Recommendation Report for Planning Permission for Works or Extension to a Dwelling

REF NO: AB/52/18/HH

LOCATION: 15 Maltravers Street
Arundel
BN18 9AP

PROPOSAL: Lowering kerb for crossover access

Drawing Name  
**Plan of Parking Area  
and access - Existing**

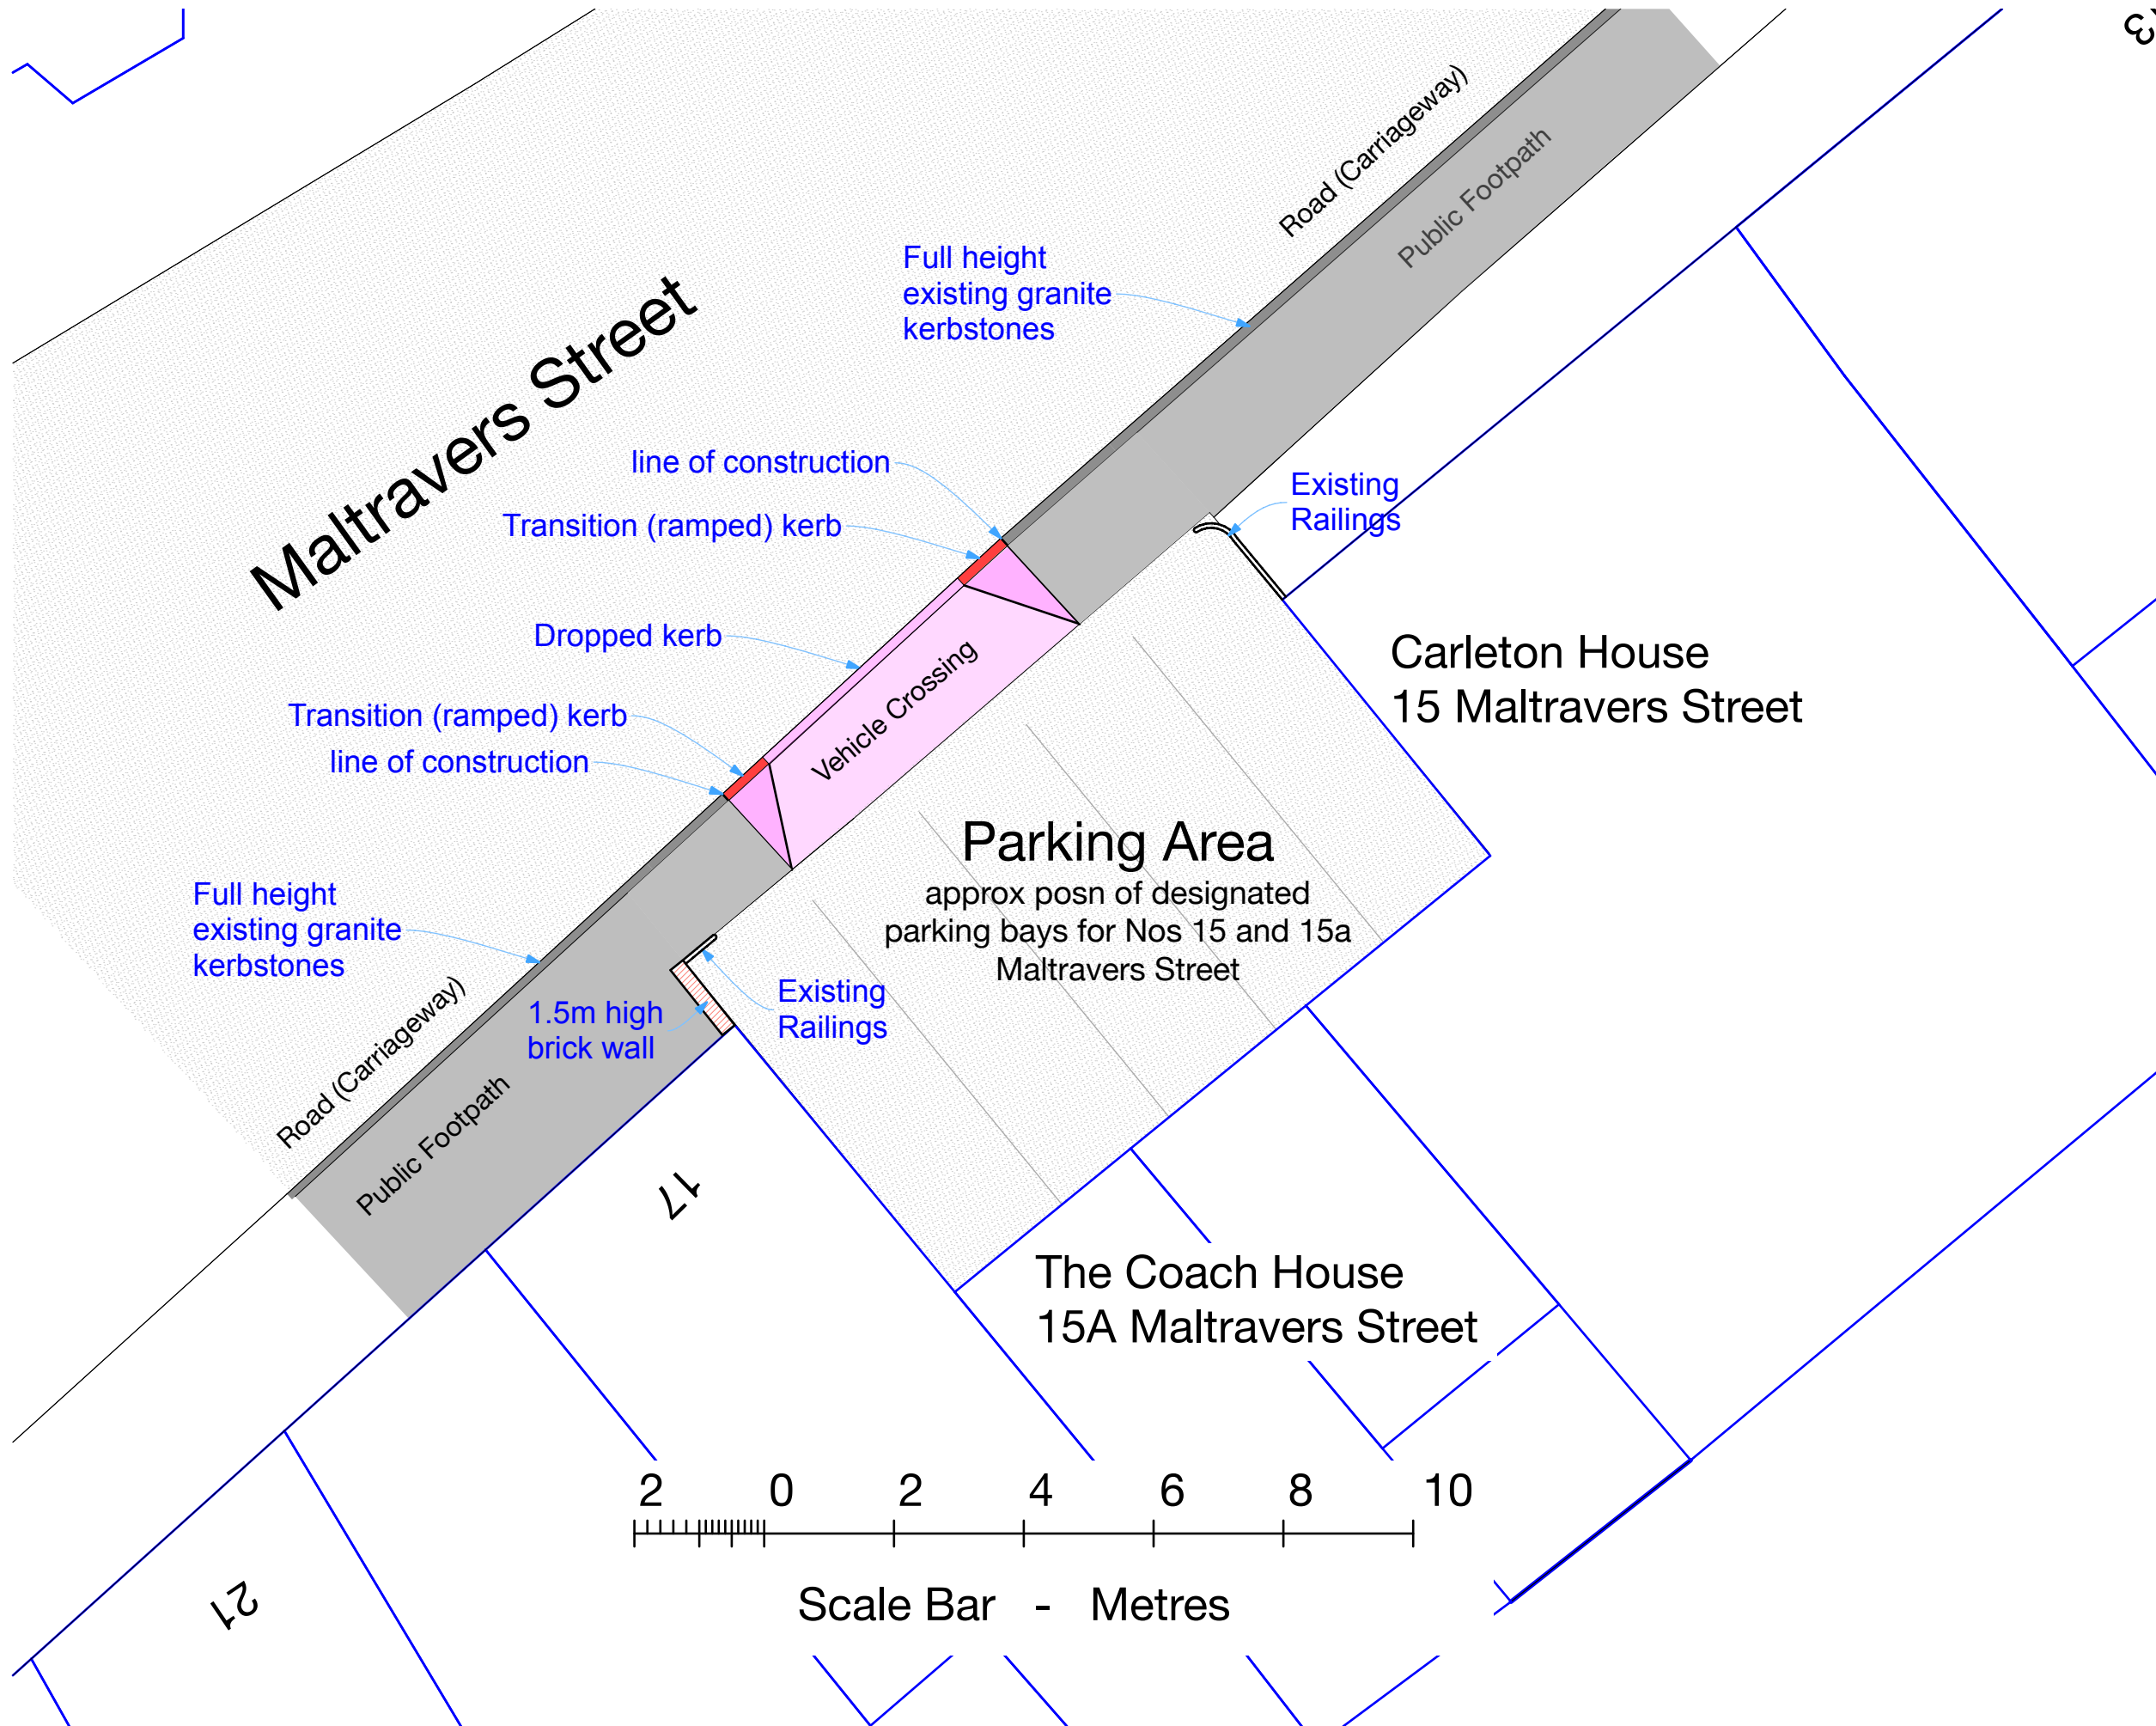
Conservation Area Advisory Committee - No objection: From their information, there would appear to be the loss of railings which would have an effect on the street scene.

'from the information..... there would appear to be the loss of railings which would have an effect on the street scene.'

Officers note that the existing and proposed plans show the same amount of railings therefore it is considered that the level of railings, to the front of the existing parking area is to remain as existing.
